RE: Avonlie Solar Farm Amended DA (SSD 9031)

RES Australia Pty Ltd provides notification to the Department of Planning & Environment (DP&E) that the Response to Submissions (RtS) includes a design change. This change is being made to alter the electrical connection for the solar farm.

Two drawings are attached, one showing the EIS layout (drawing number 03819D1001-02) and one showing the amended DA RtS layout (drawing number 03819D1001-04).

DRAWING NUMBER  
**03819D1001-04**

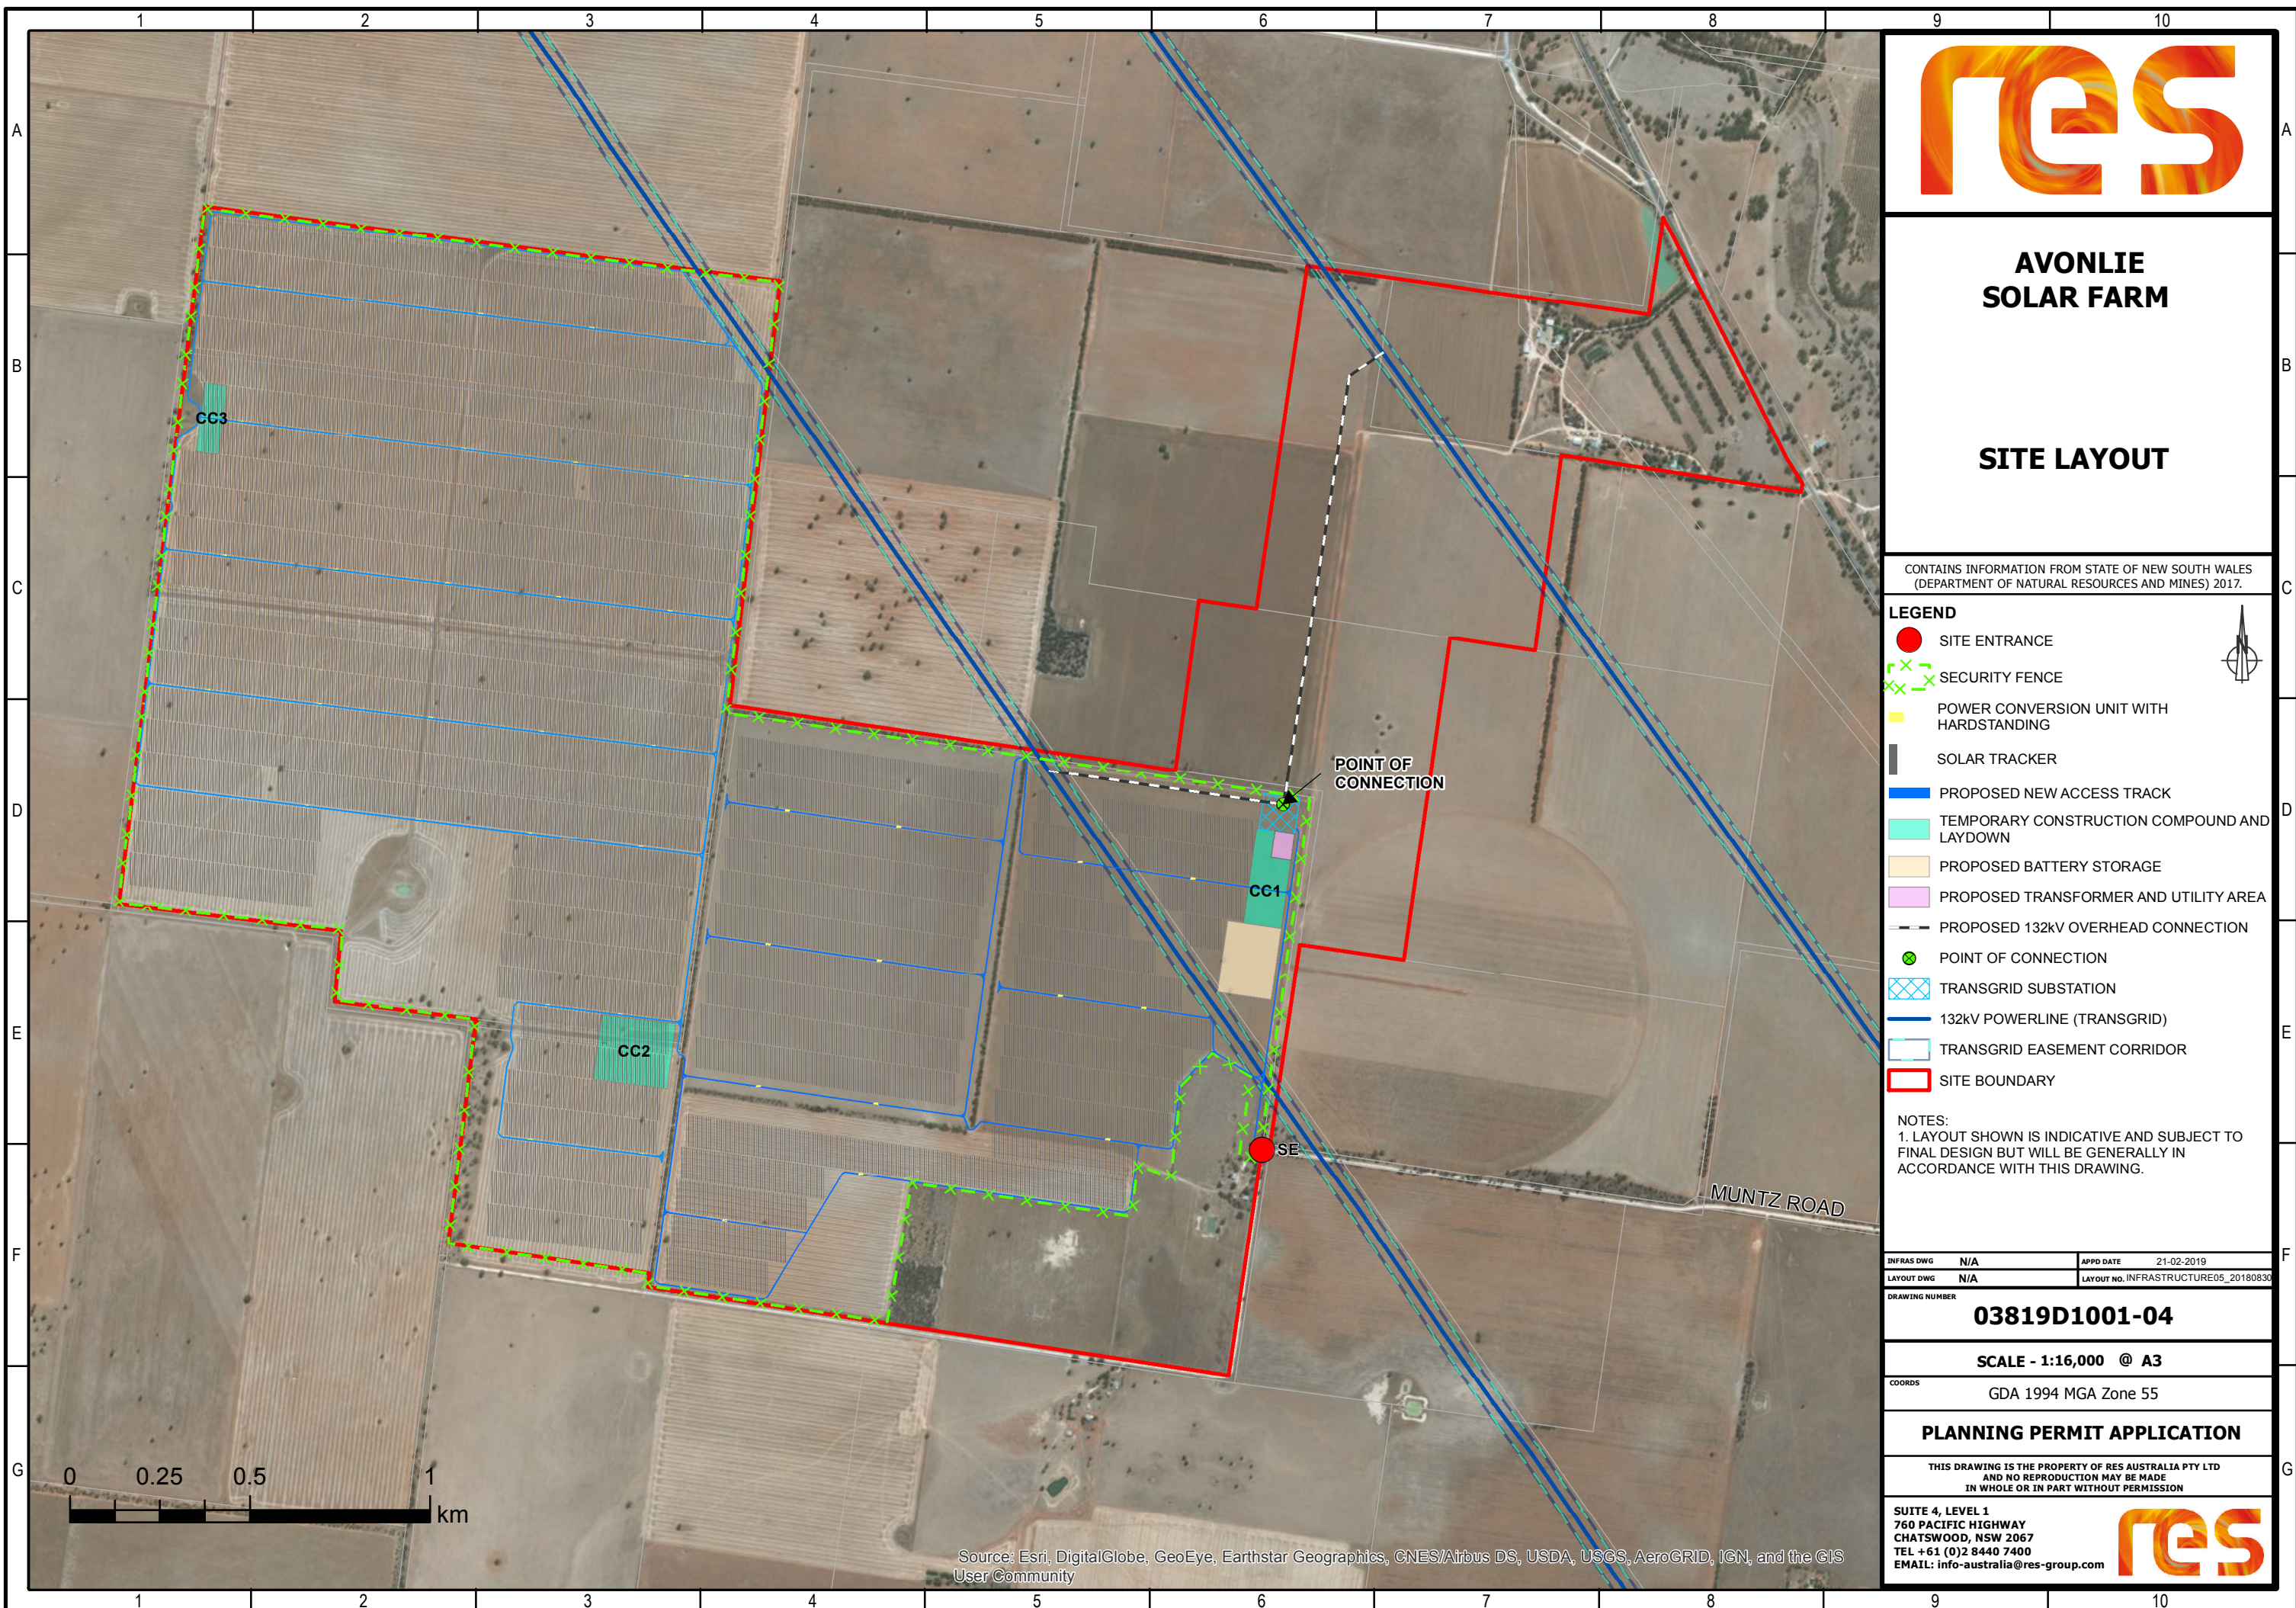
The Environmental Impact Statement (EIS) design utilised a single connection into the existing TransGrid 132kV overhead line running through the project area. The revised design now features an additional overhead line connection into a second existing 132kV overhead line located a short distance to the north east. This change is being made to provide a more stable connection with lower constraint and outage risk. This change has been made following consultation with TransGrid who own and operate both existing 132kV overhead lines.

- Movement of the substation, transformer and utility area, battery storage facility and construction compound area 1 approximately 0.6km north. This is to site the substation between the two existing 132kV overhead lines. All moved infrastructure remains within the original development footprint.
- Additional 132kV overhead line (around 0.6km) to connect the revised substation location into the existing 132kV overhead line running through the project area. This change is within the original development footprint.
- Additional 132kV overhead line (around 1.2km) to connect into the second existing 132kV overhead line. This change is outside the original development footprint. The additional

area required for this overhead line easement has been assessed, with additional updated assessments included in the RtS. The Development Boundary has been modified to include this additional overhead line easement by inclusion of Lot 7DP254595, Lot 28 DP754538, Lot 13 DP795880 and Lot 1 DP386927.
